Response to ISH4 and ISH5 Action Points

This document provides Cambridgeshire County Council (**CCC**) and Fenland District Council's (**FDC**) (together, **the Councils'**) responses to the Action Points addressed to CCC and/or FDC arising from the Issue Specific Hearing 4 (ISH4) held on 17th May 2023 and the Issue Specific Hearing 5 (ISH5) held on 18th May 2023, with regards to the Medworth Energy from Waste (EfW) Combined Heat and Power (CHP) Facility.

- Notes:
1. Proposed visibility based on New Bridge Lane being subject to a revised 30mph speed limit.
  2. New street lighting has been provided on an indicative basis (at 30m intervals and at conflict areas) and will require detailed design and assessment.

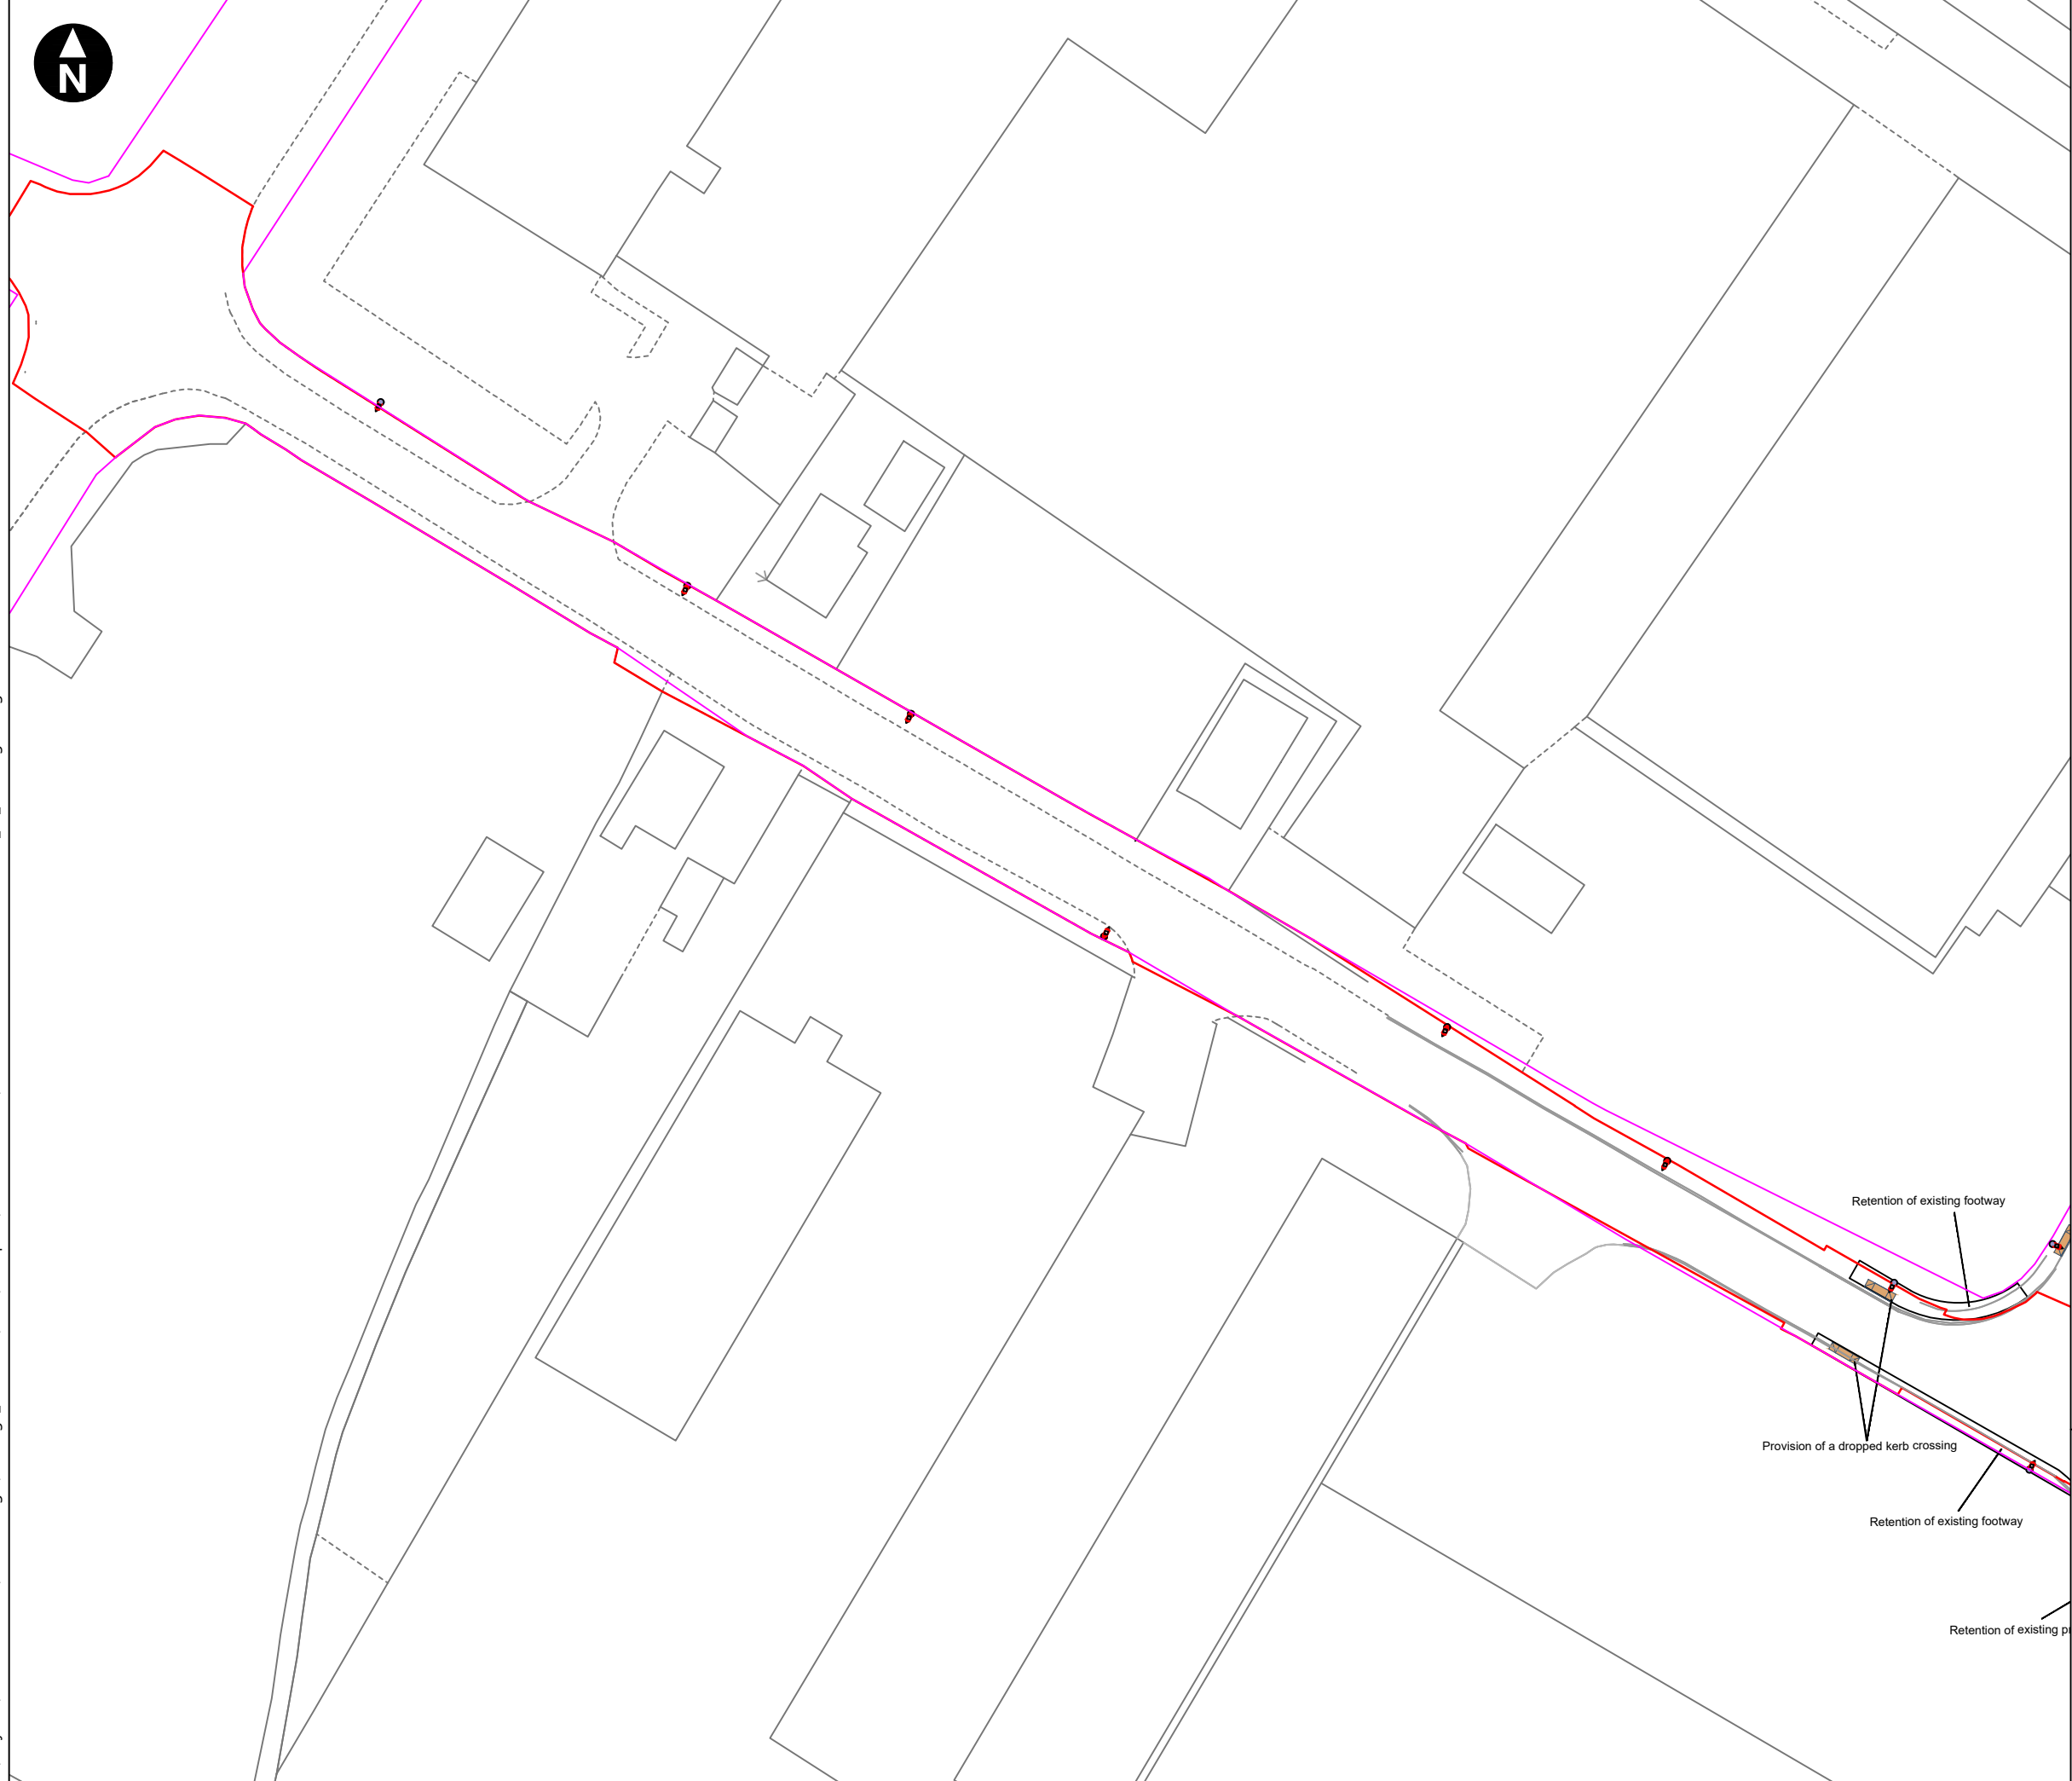
Action No.	Party	Action	Deadline	Response
2	Applicant Cambs CC	Applicant and CCC to engage on outstanding issues in relation to Highways issues – including Protective Provisions, particularly payments for highway damage, and to update ExA and SoCG to reflect this.	Deadline 5	<p>The Applicant has engaged CCC on the following matters:</p> <ul style="list-style-type: none"> • Draft Heads of Terms for a Section 278 agreement (Highways Act 1980) for works within the highway. CCC returned its comments to the Applicant on 31 May 2023. The Applicant provided CCC with an updated draft S106 heads of terms on 13 June 2023. CCC are currently reviewing the proposed head of terms and will provide feedback to the Applicant accordingly. • Draft Protective Provisions proposed for inclusion in the DCO. CCC's consideration of the Applicant's first draft is ongoing. • Design of highway works affecting New Bridge Lane, and the proposed pipe bridge over Weasenham Lane.
